Modification of Approval

Restoration and refurbishment of the Sirius Site (SSD_10384_Mod 3)

2-60 Cumberland Street, the Rocks

August 29, 2022

2 GA - WEST ELEVATION_CUMBERLAND
1 : 200

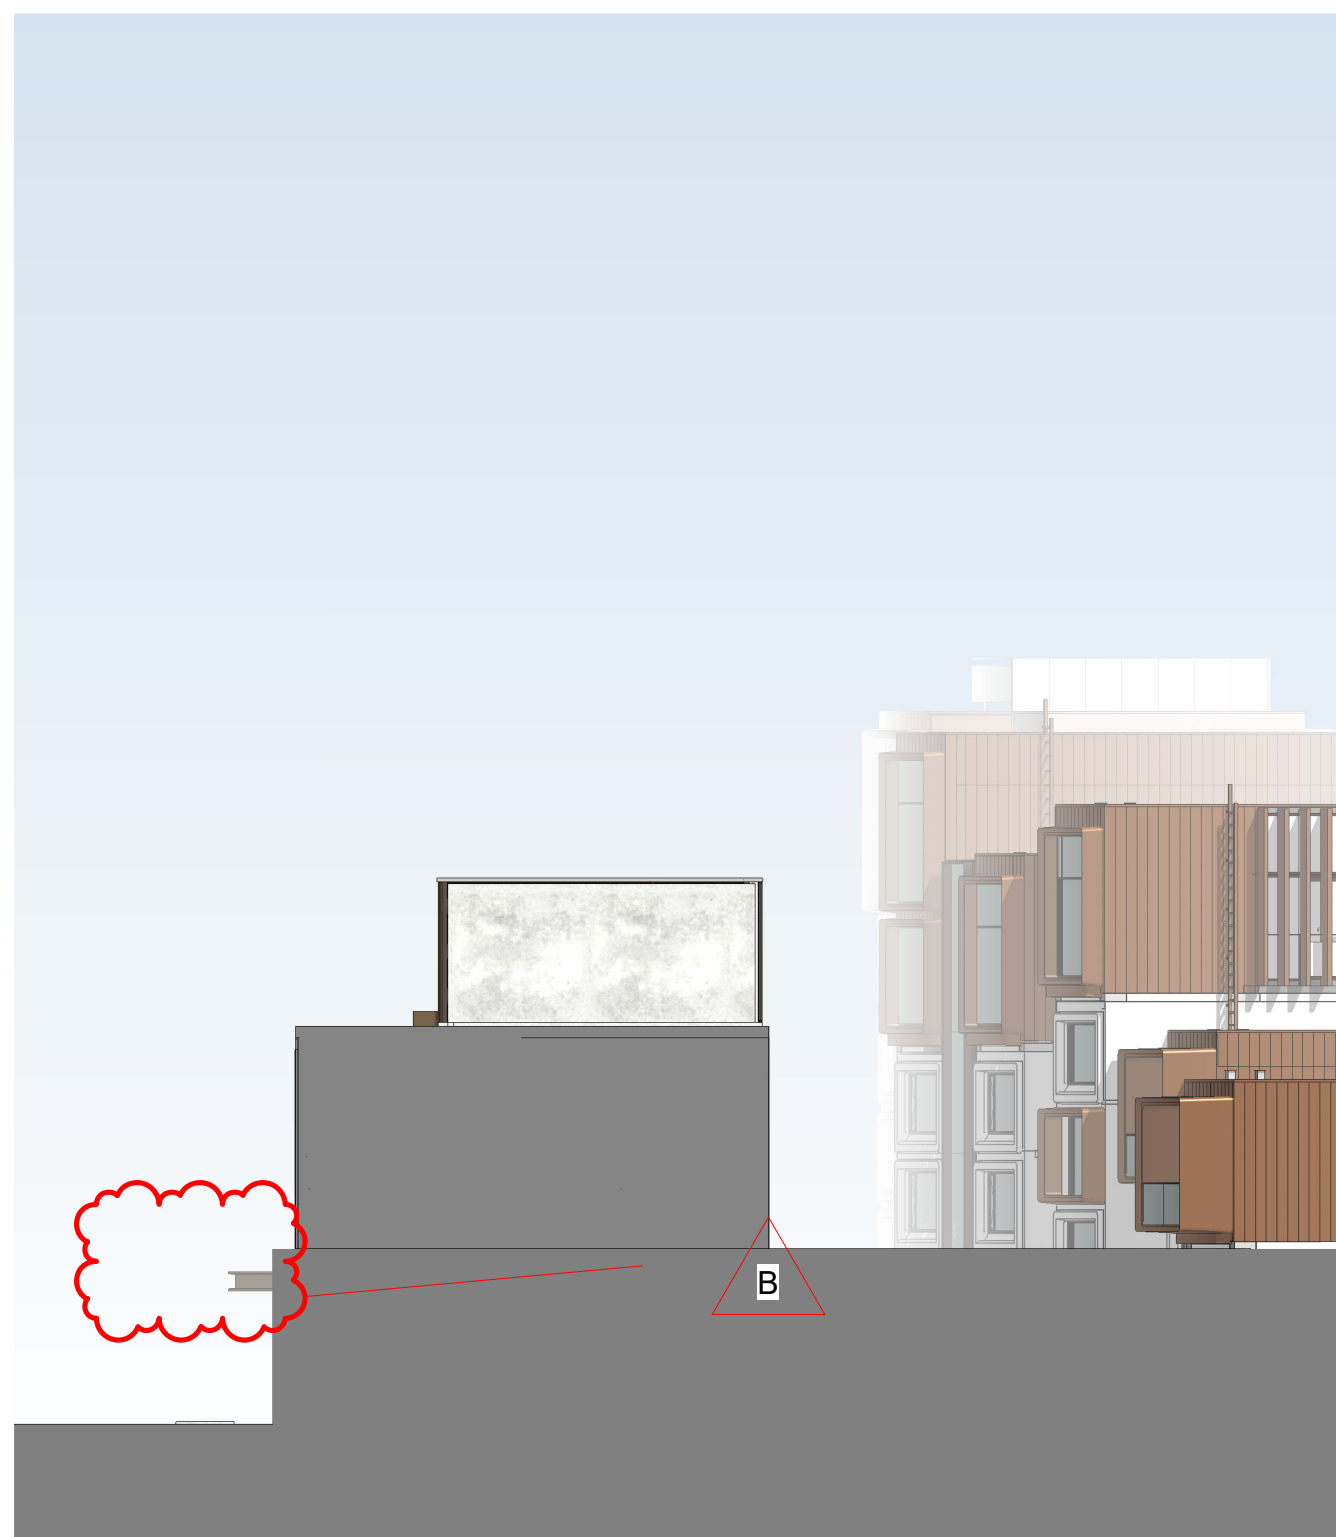
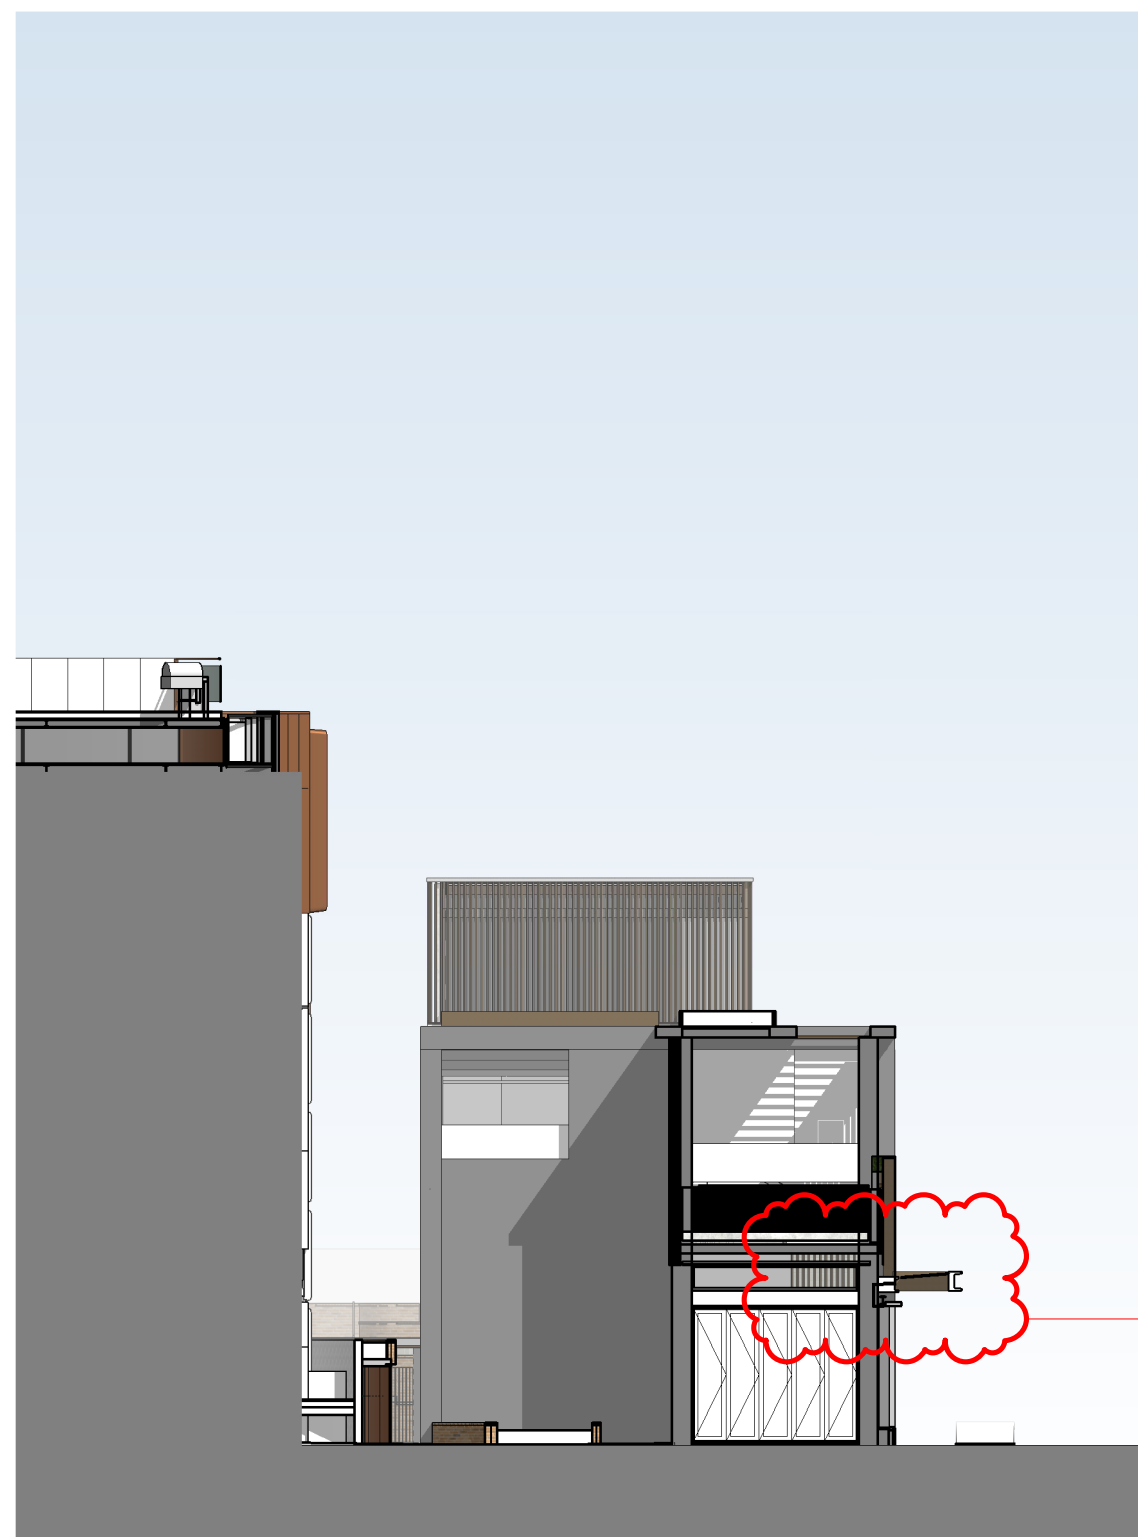
This modification proposes to make the following changes to the awning fronting Cumberland Street:

- Reduce the width from 3m which extended to the face of the kerb to 1.78m to avoid any conflicts with vehicles on Cumberland Street and for greater consistency with the Sydney DCP which requires awnings to be setback 1m from the face of the kerb
- Increase the height from 2.50m to 3.20m to ensure consistency with the Sydney DCP which requires awnings to be between 3.2m and 4.2m above the footpath.

This is shown at Figure 2 and in the plans at Appendix B. The relevant provision of the Sydney DCP are further discussed in Section 4.4.

Figure 2: North Elevation Approved (RHS) and Proposed (LHS)

The amended awning would have a height of 3.20m consistent with the DCP requirement. The proposed width of 1.78m is less than required range of 2m to 3.6m but meets the requirement to be at least 1m from the face of the kerb.
